28 August 2019

Ref: 038002/L003

PROPOSED EQUESTRIAN/AGRICULTURAL FACILITIES AT ELMRIDGE FARM, ELMRIDGE LANE, CHIPPING, PR3 2NY – 3/2019/0690

TITLE: **Proposed Floor Plan & Elevations**

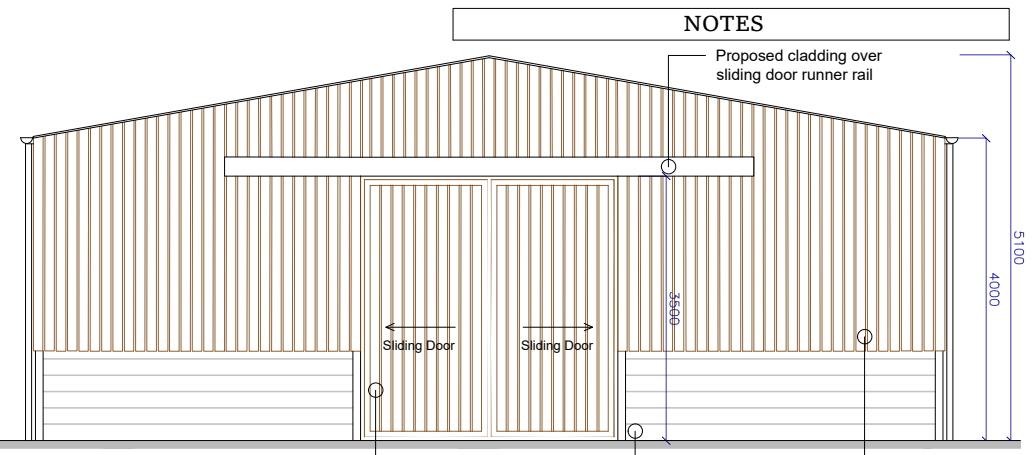
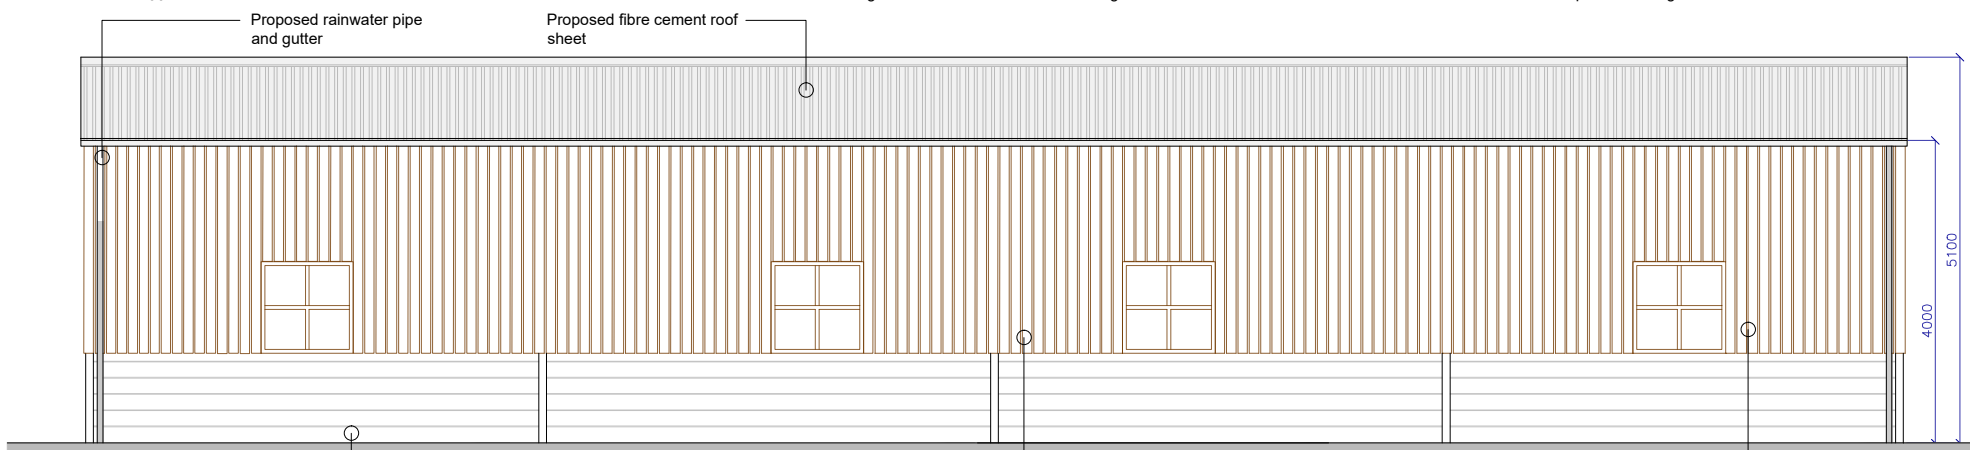
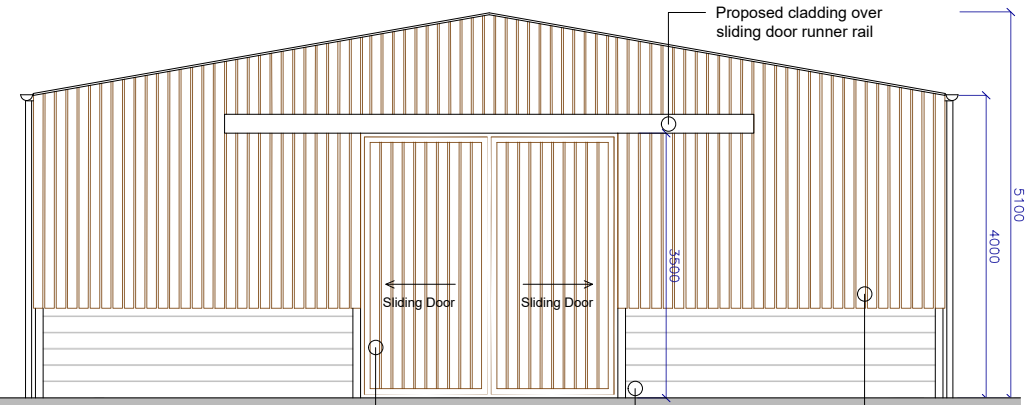
Following our discussion, the barn elevations have also been revised to provide a block wall at lower level below the timber cladding.

Proposed Site Layout

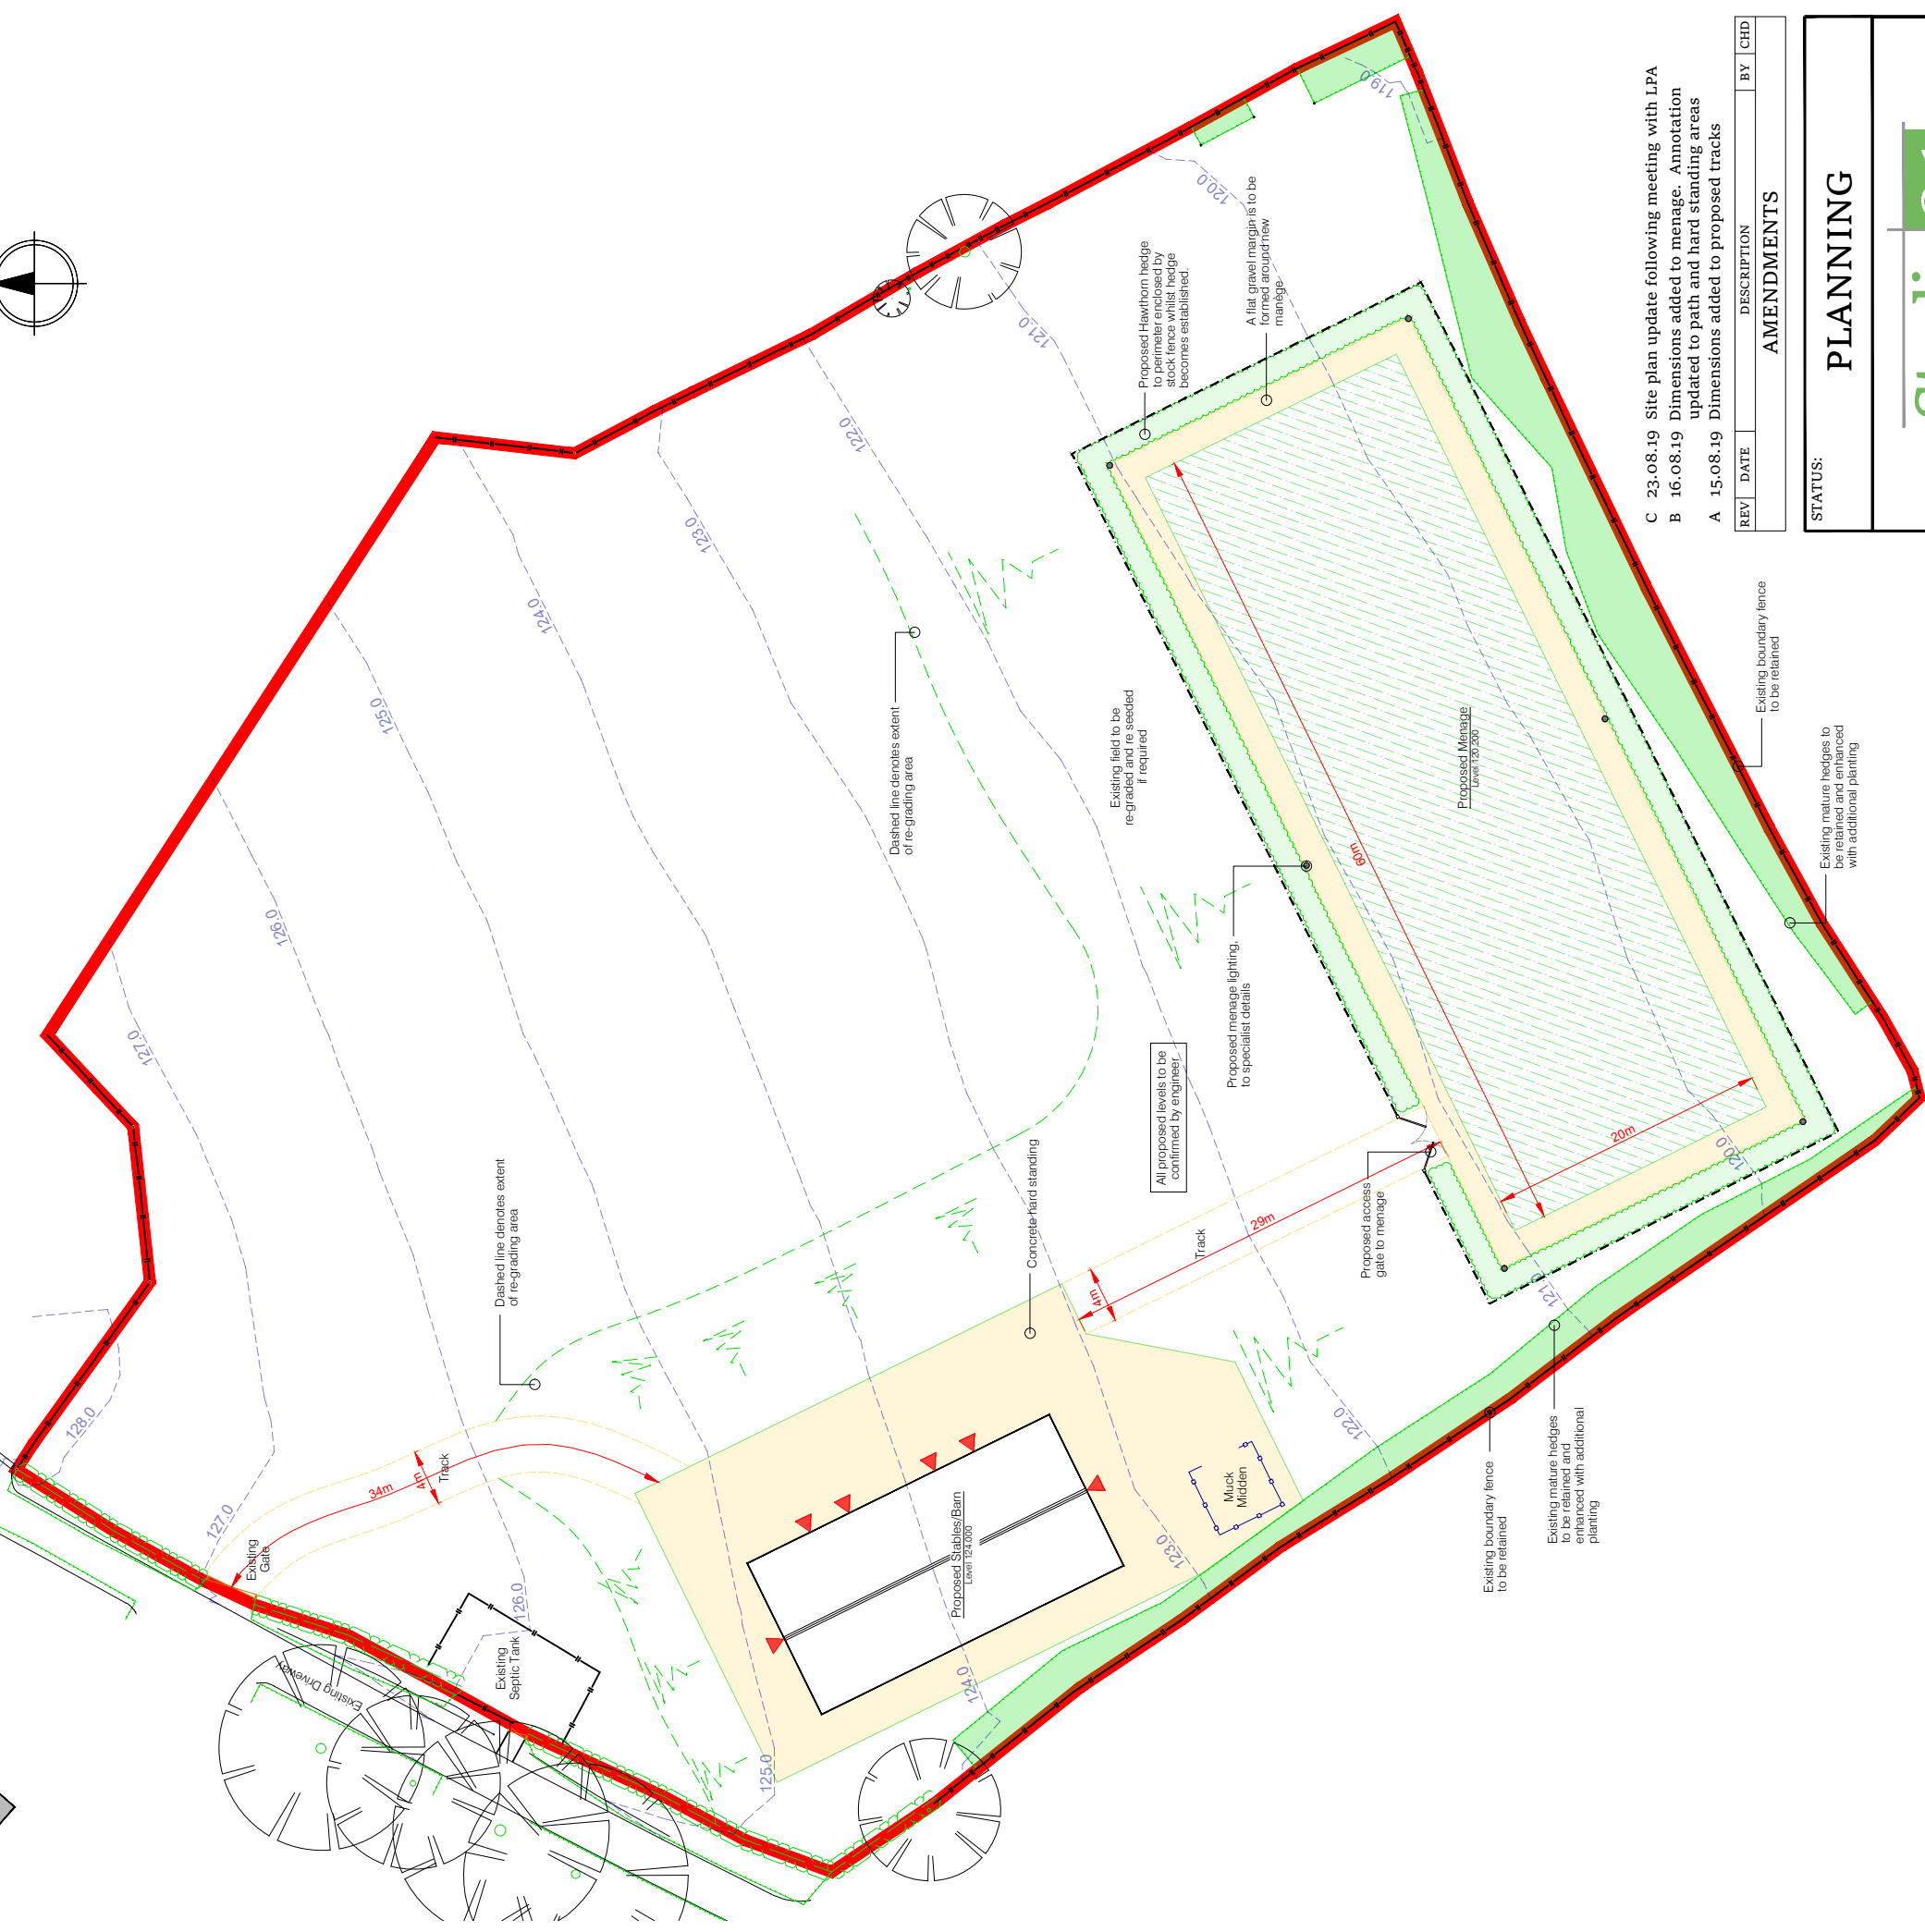
As requested, the Proposed Site Layout plan has been revised to include reference to the erection of stock fencing around the menage to protect the perimeter hedge whilst it becomes established. The

area of hardstanding around the proposed building has also been extended to include the muck midden and access to it. The Section drawing has also been updated to reflect this and lower lighting columns for the menage.

TITLE:
Proposed Site Sections

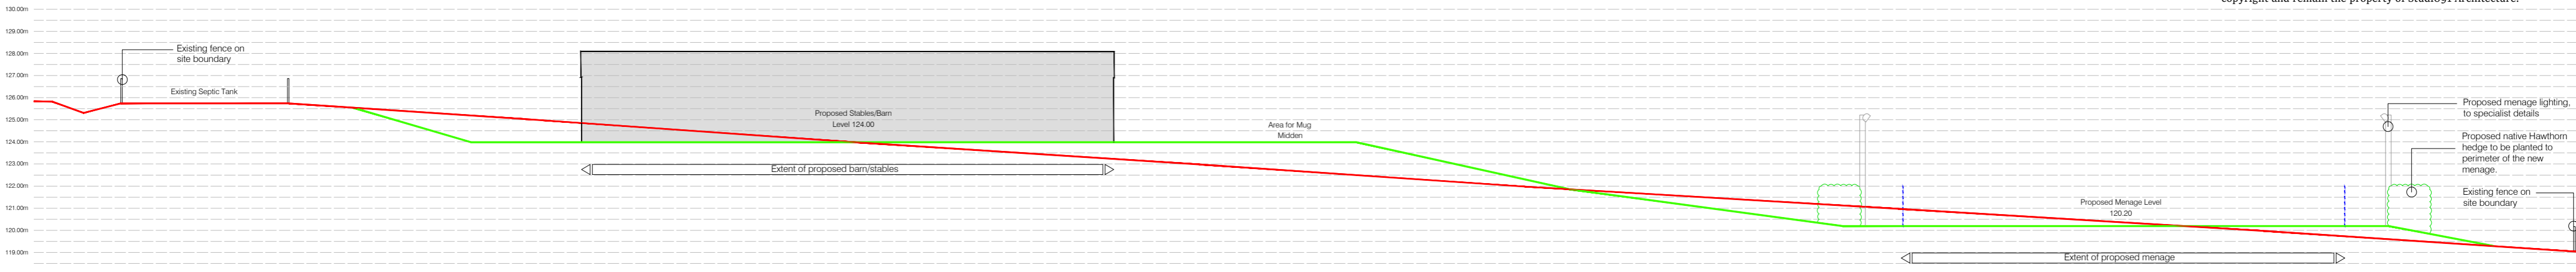
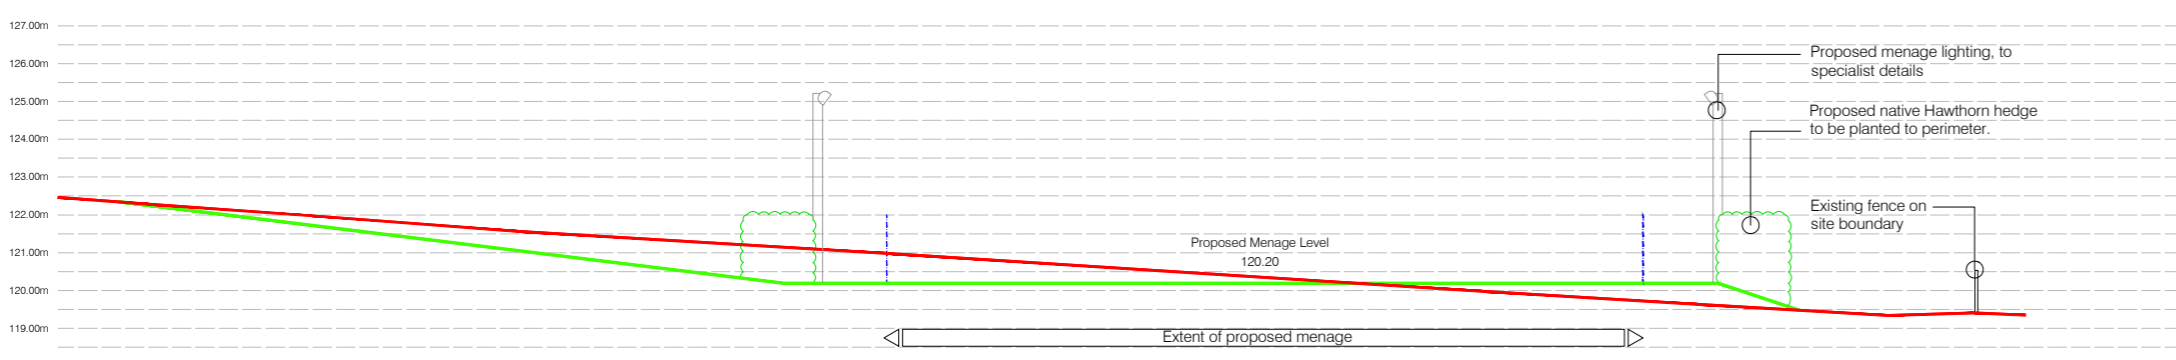
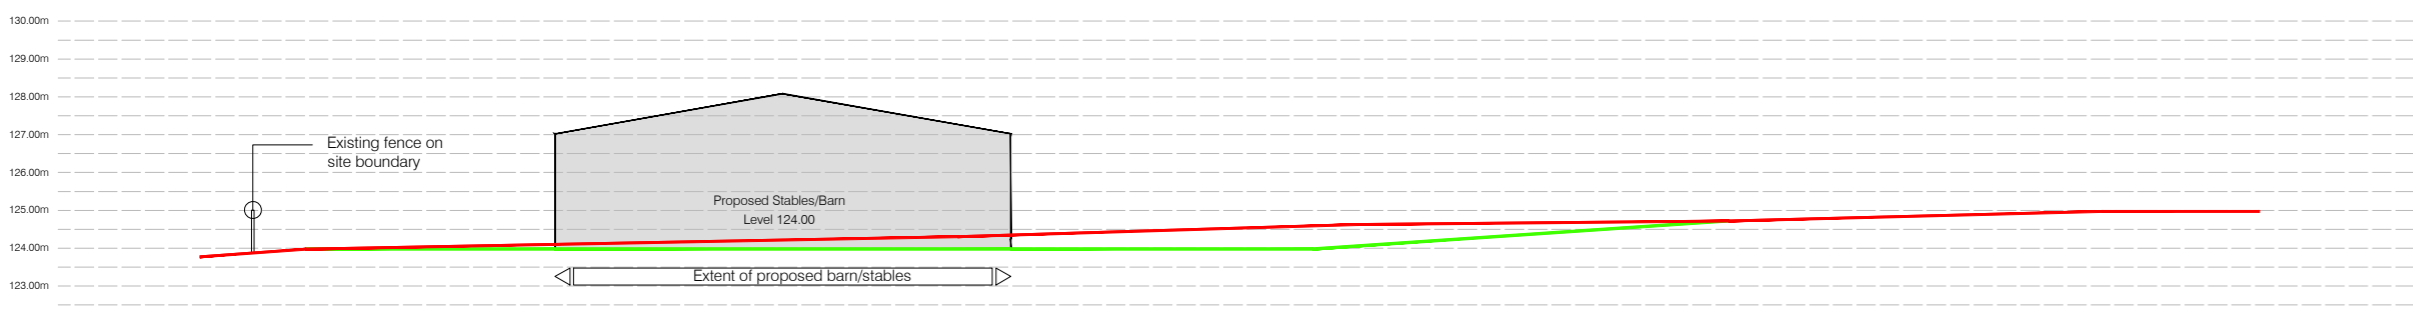
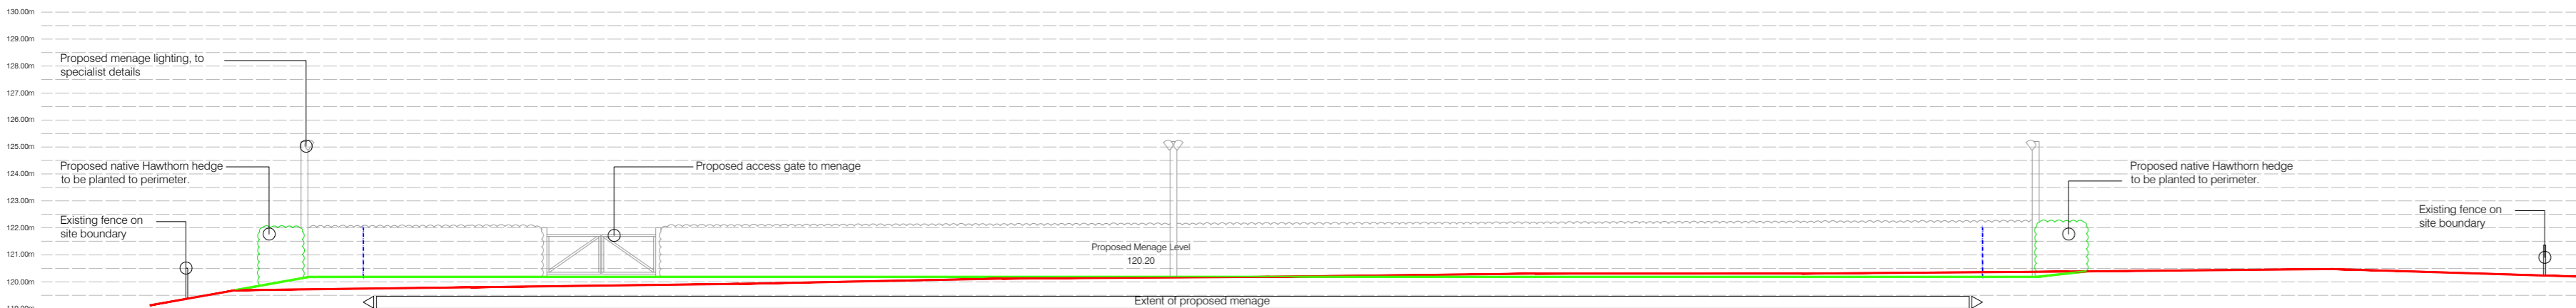
Whilst the submitted section drawing indicates that the lighting columns will be 6m high, the Applicant has confirmed that 5m high columns may be sufficient. It is proposed that the details of the lighting scheme be agreed by condition prior to installation.
